FIRE RISK MANAGEMENT, INC

Memo Report

Subject: Code Review; ICW Proposed 133 York Street Apartment Building Site Access

SITE PLAN MAP 44/BLOCK A/LOTS 29 & 31

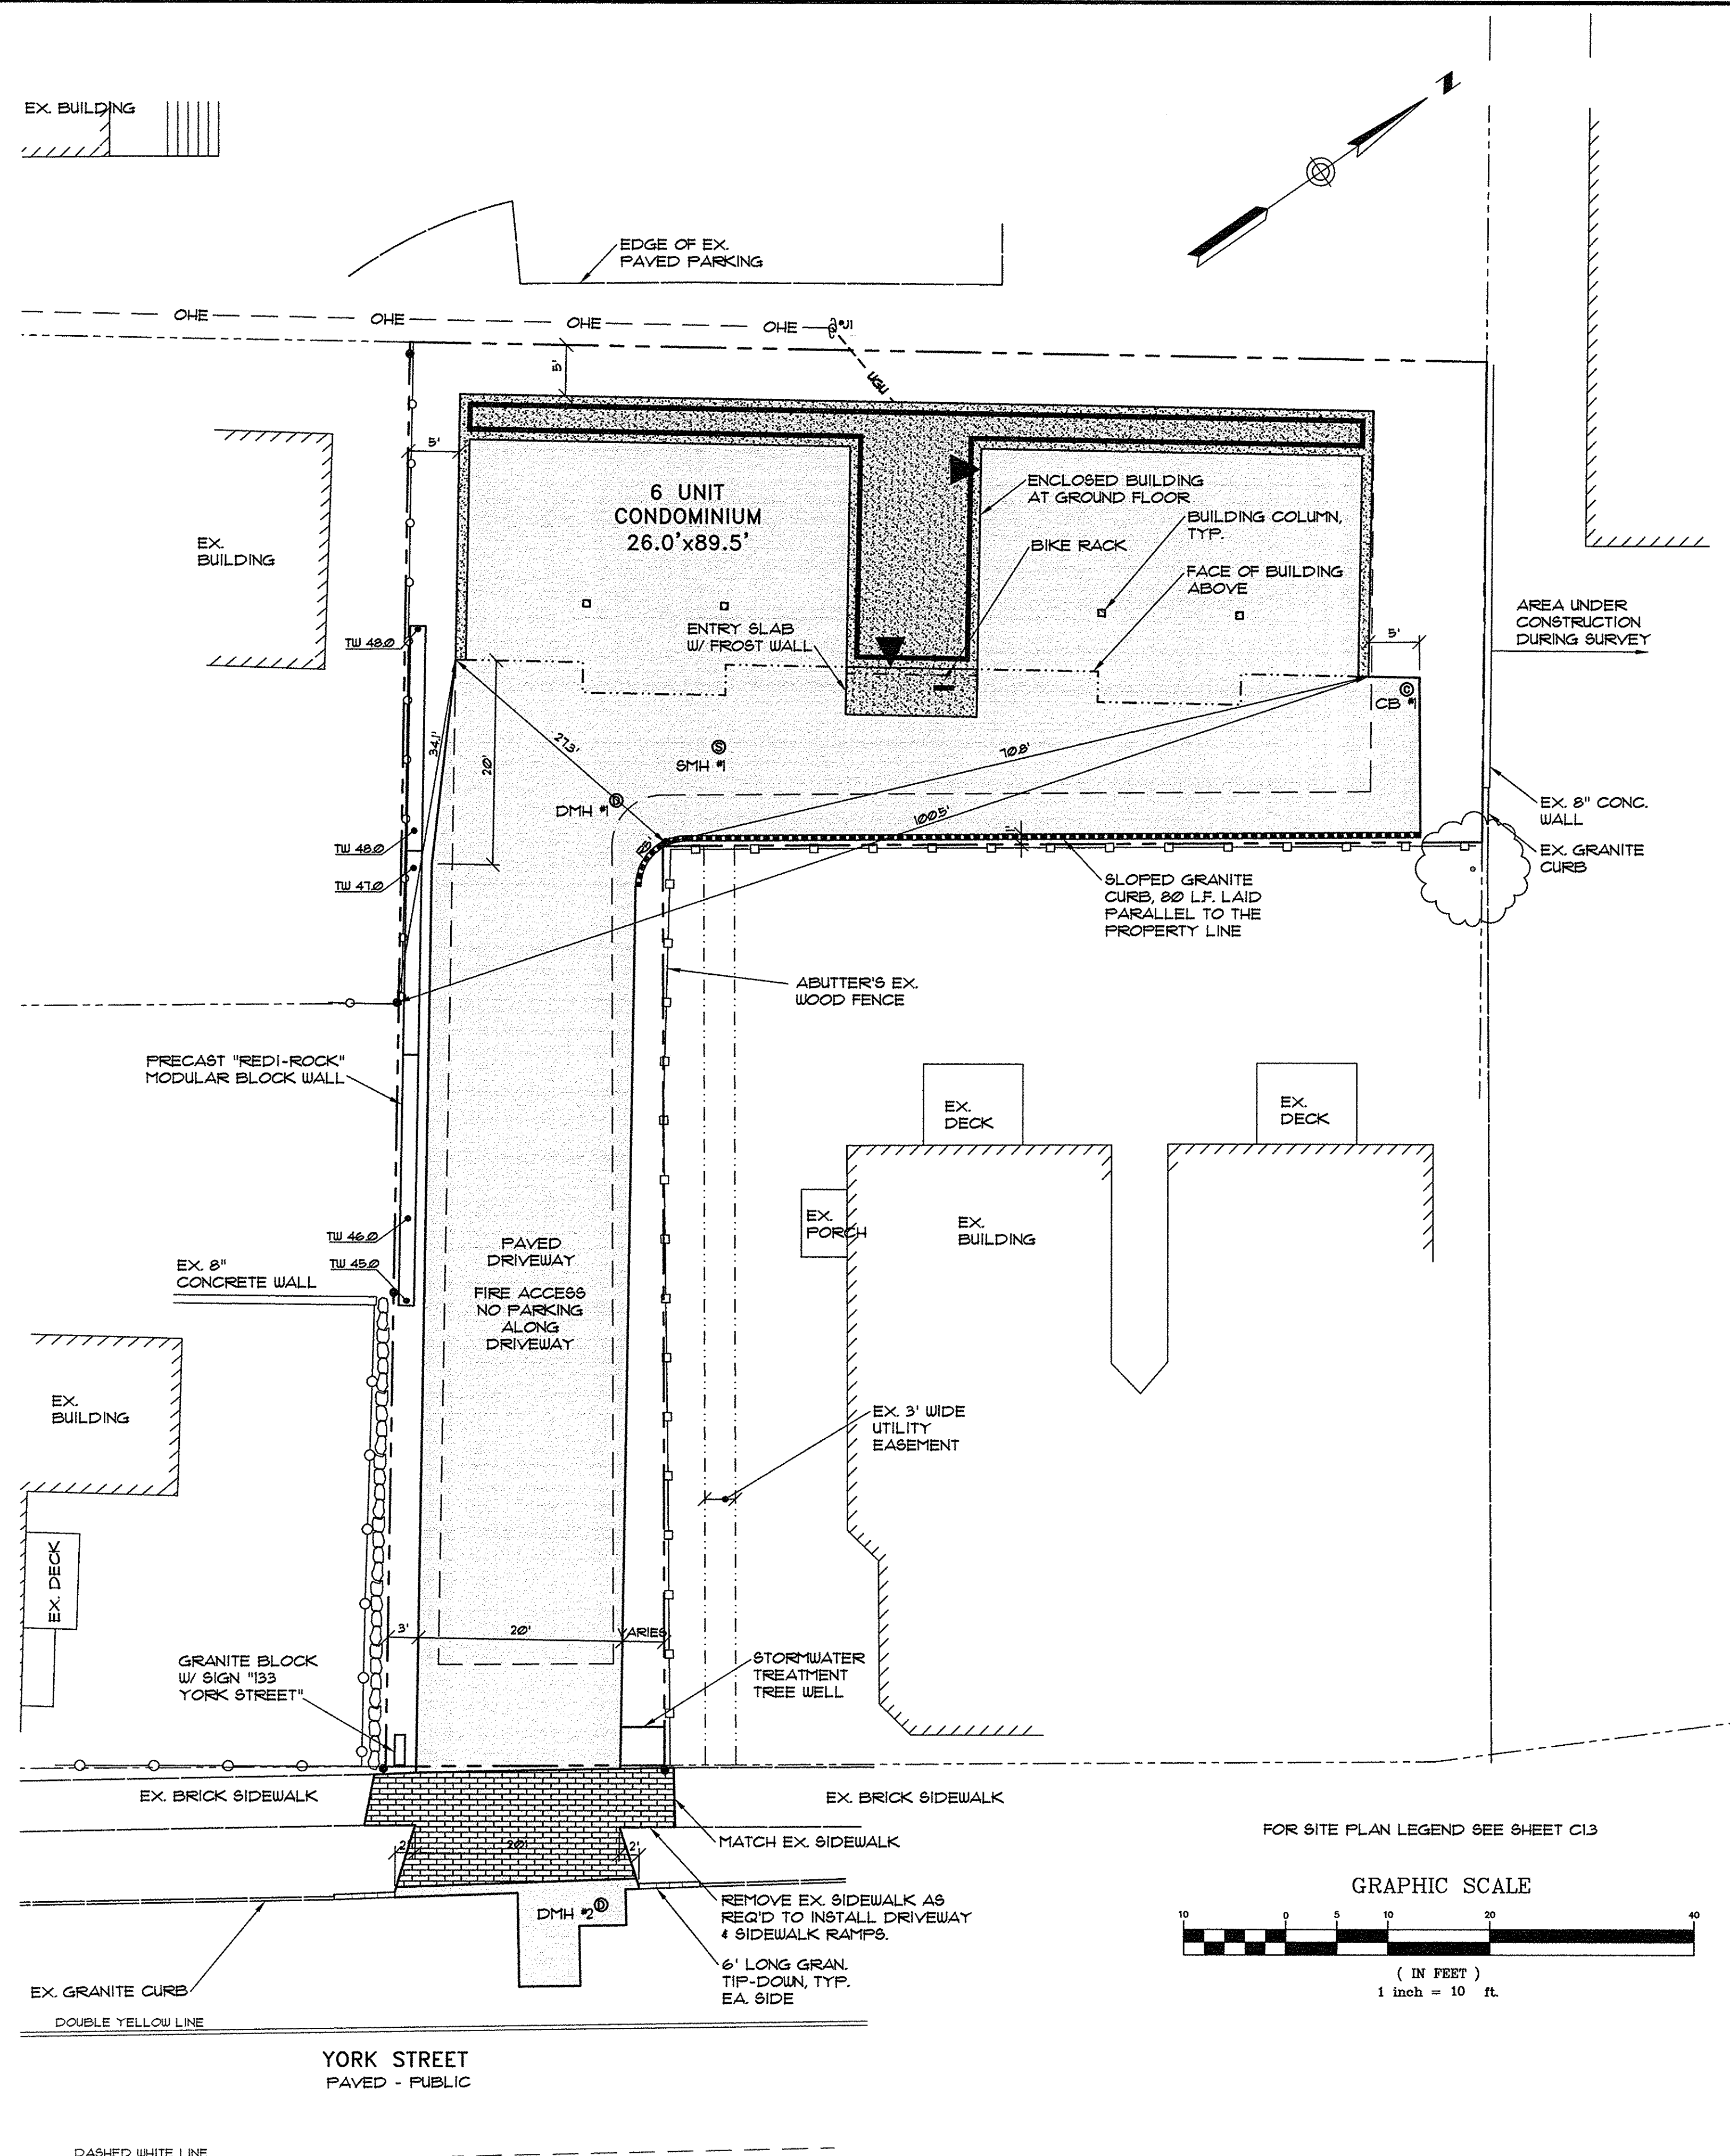
- *The access road must be at least 16 feet in width to meet City requirements.* The NFPA 1 would require this access road to have at least 20 feet in clear width. The driveway (access road) shown on the site plan will provide up to 20 feet of clear width.

- *Any dead-end access roads in excess of 150 feet must be provided with an adequate turn-around area.* Since the turn radius from the driveway into the parking lot area is not sufficient to accommodate fire department apparatus, this access road is considered a dead end. The distance from the street to the front wall of the building is less than 120 feet. As such, this access road is not required to be provided with a turn-around area. The access road is completely straight and should not present much of a challenge for fire department personnel to back the apparatus out of the driveway once firefighting operations are complete.

- *At least one (1) fire hydrant must be within 250 feet of this site. The City also has a requirement that a hydrant must be within 100 feet of any Fire Department Connection (FDC).* A fire hydrant is located at the corner of Park and York streets. This location is easily within the 250 foot limit. However, the distance from the hydrant to the likely location of the building's FDC, when following the likely route for laying hose, will be outside the 100-foot limit.

Although the access road will meet the minimum width requirements, it will also be necessary that "No Parking" signs be placed along this driveway to ensure that it always remains clear.

With the exception of the distance between the closest fire hydrant and the building's FDC, the site design plan for this building should meet all requirements for site access and water supply as outlined in both NFPA 1 and the City's Fire Department Rules and Regulations. To support the distance requirements between a fire hydrant and the FDC, two options exist; 1) install a new, private fire hydrant in the vicinity of the building, such that it will be within 100 feet of the planned location of the FDC, or 2) install a remote FDC near the end of the access road. In either case, measures must be implemented to ensure that the hydrant or FDC are protected from damage and remain accessible, including during the winter months.
